Transgrid Reference Number: 2025-283

NSW Planning Portal DA: SSD-69783064

Proposal: Wagga Wagga Lithium-Ion Battery Recycling Facility

DETERMINATION: Additional Information Required

Figure 8.3 Catastrophic rupture explosion contours for 5/D weather

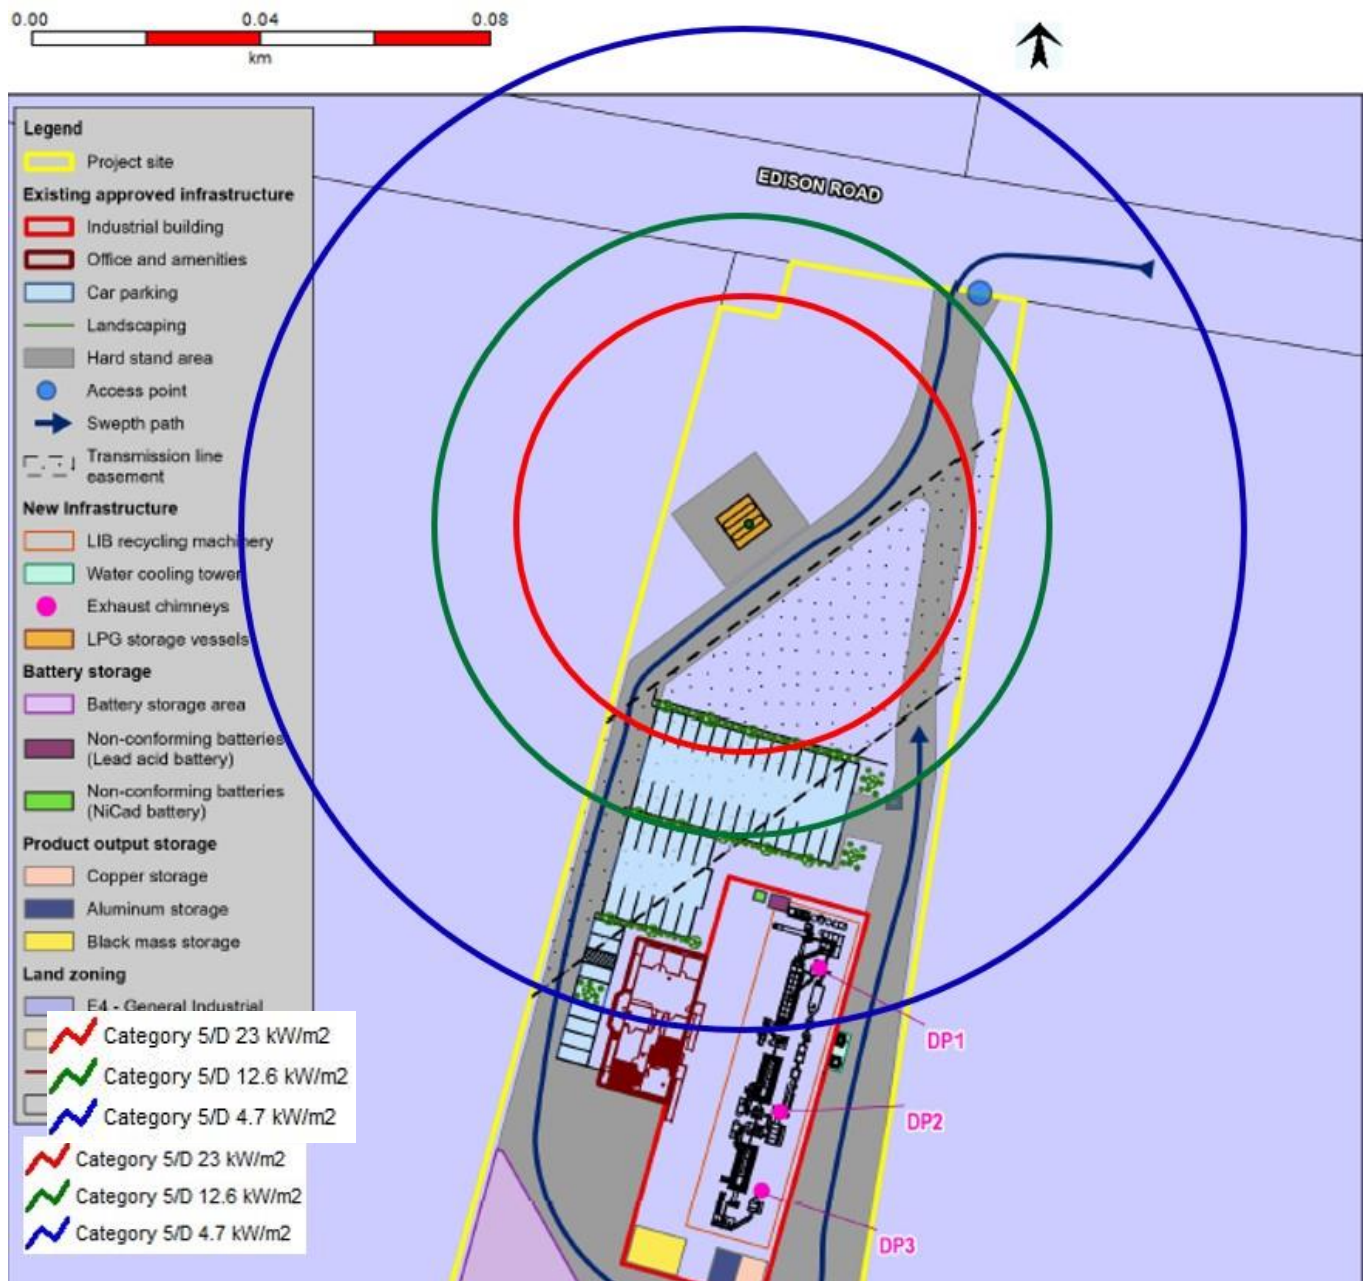
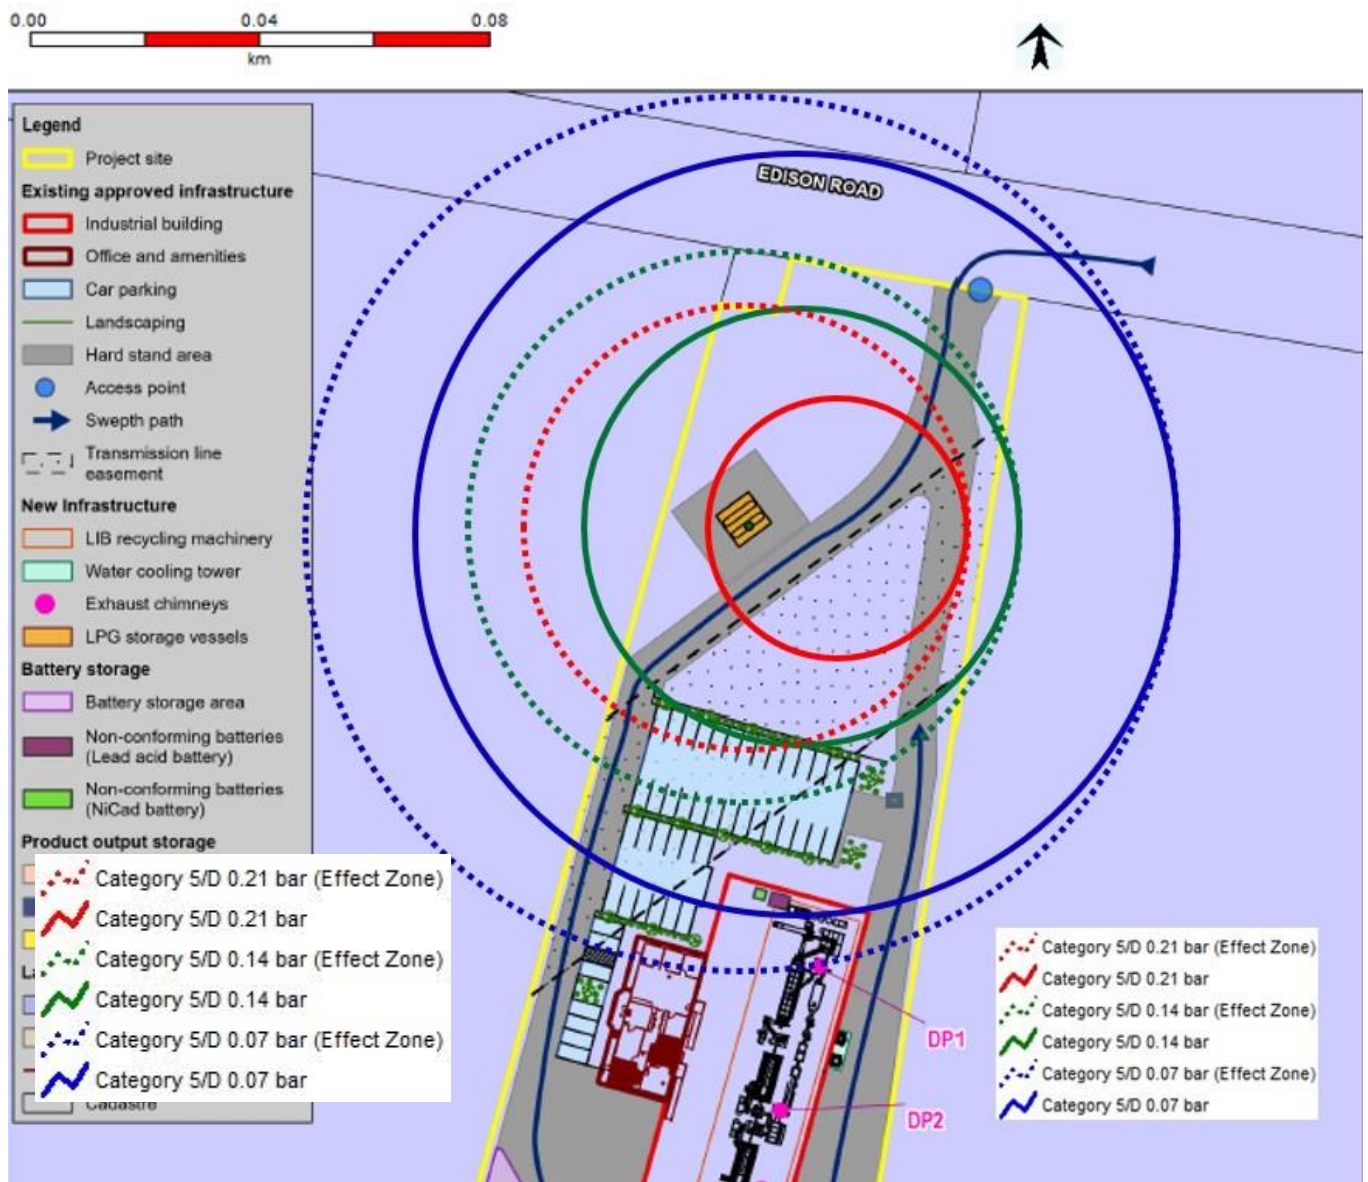
1. Appendix F does not adequately address Item | 34 *Hazard and Risk - Summary of Issues* raised within the applicant's response.
 - i. The applicant did not assess impacts to the conductors in the air that is overcrossing the storage area. Appendix F states that the transmission line (structure, conductor and fittings) is considered not be damaged by the radiant heat/overpressure contour. The transmission line (conductors) passes through the Category 5/D 23kW/m² zone in Figure 8.4 and Category 5/D 0.14 bar in Figure 8.5. These 2 categories are identified as causing property damage.

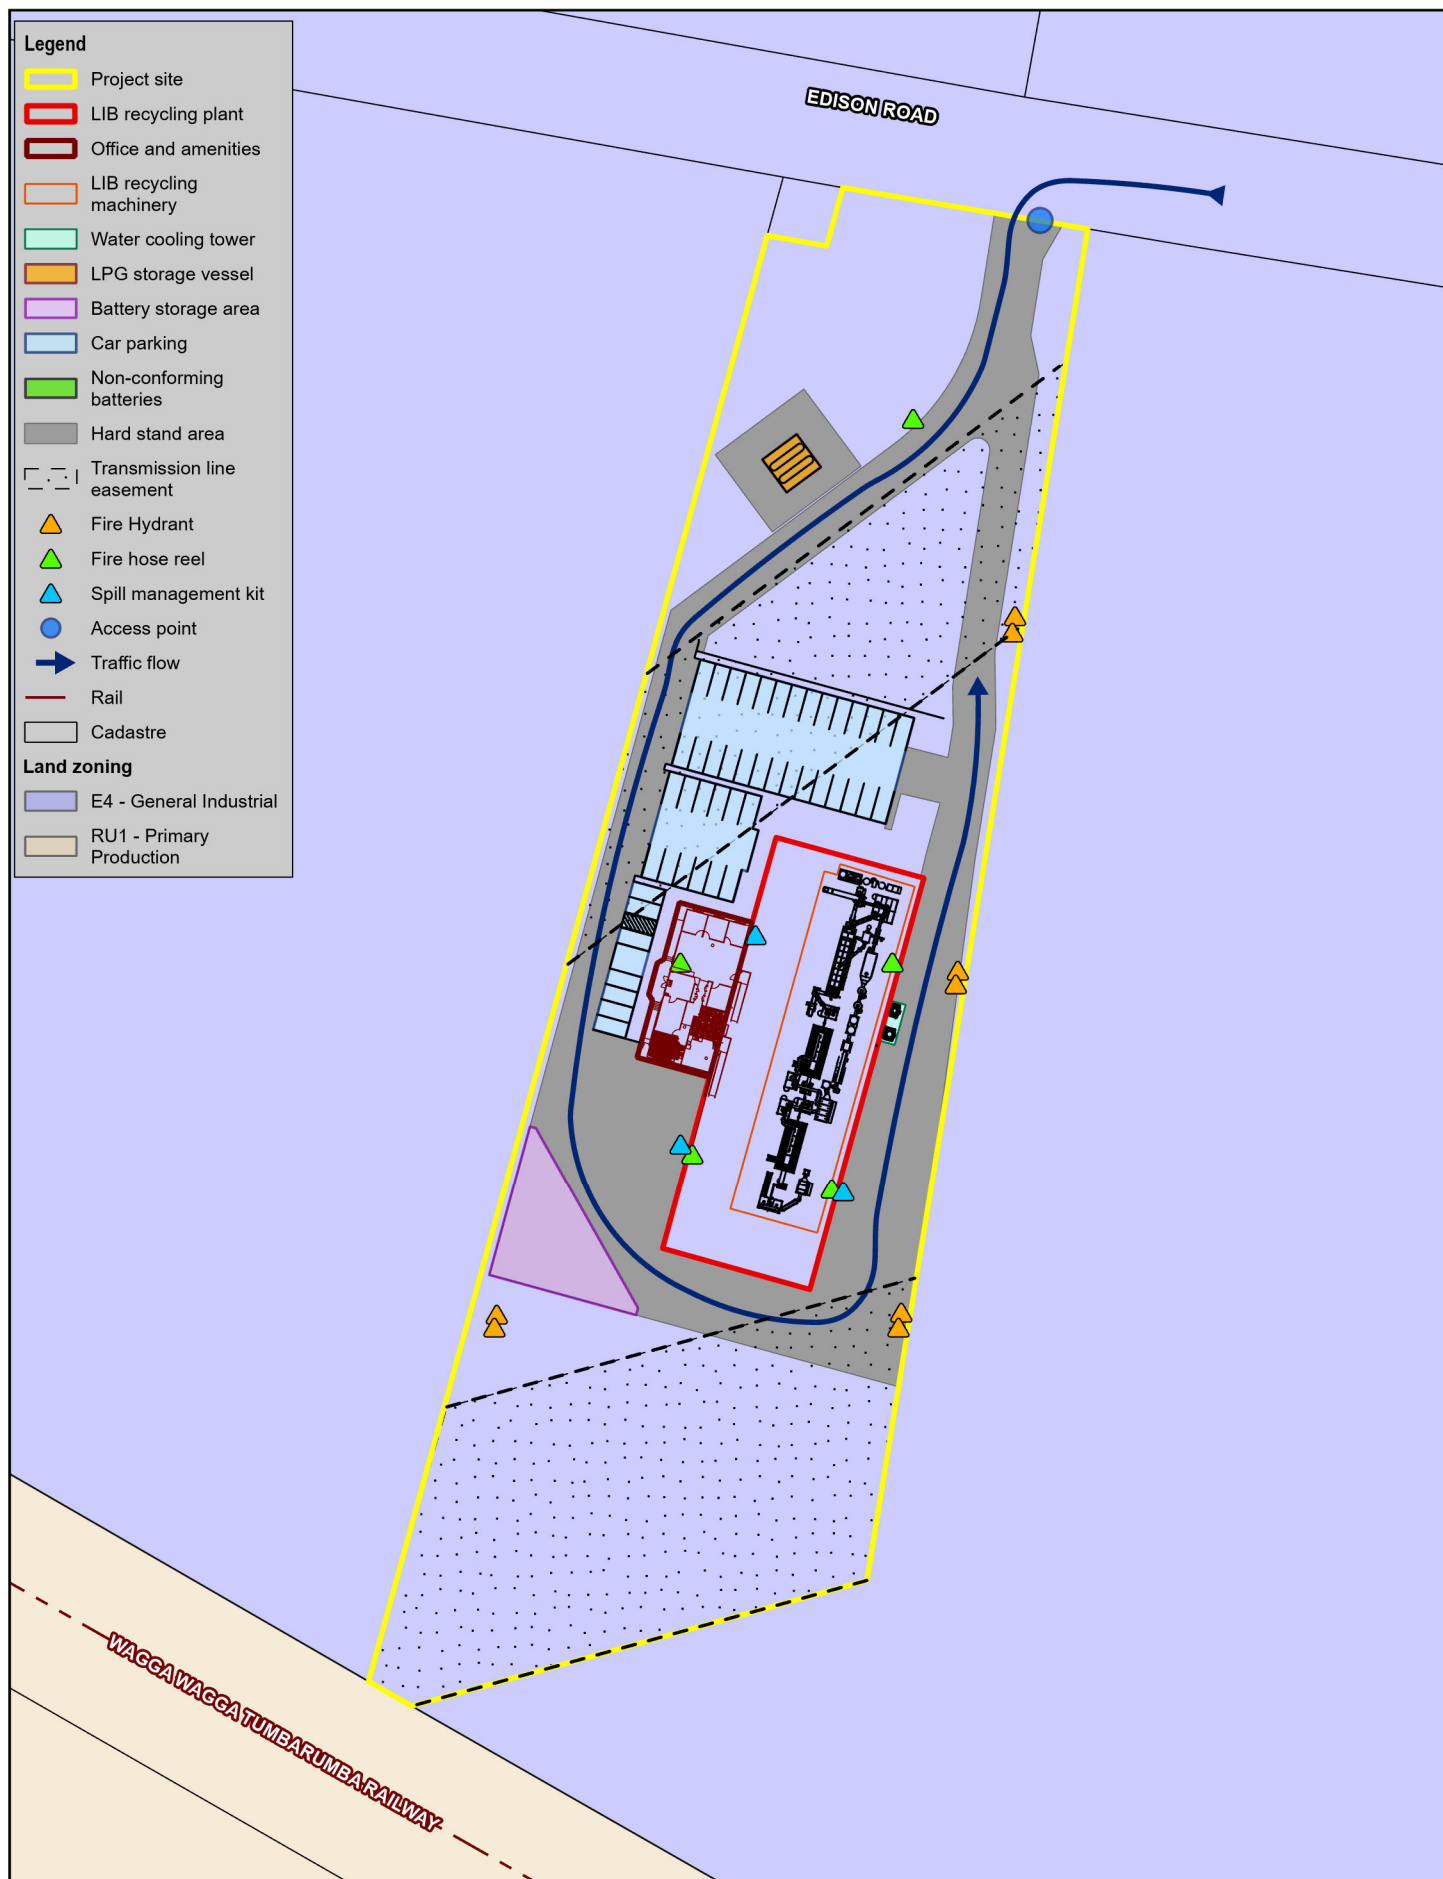
2. Figure 9.1 Site Layout and emergency equipment (dated 4/12/25).
 - i. Please provide an updated plan confirming that all proposed fire hydrants are to be located outside of Transgrid's Easement corridor. Refer to *Transgrid's Easement Guidelines*.
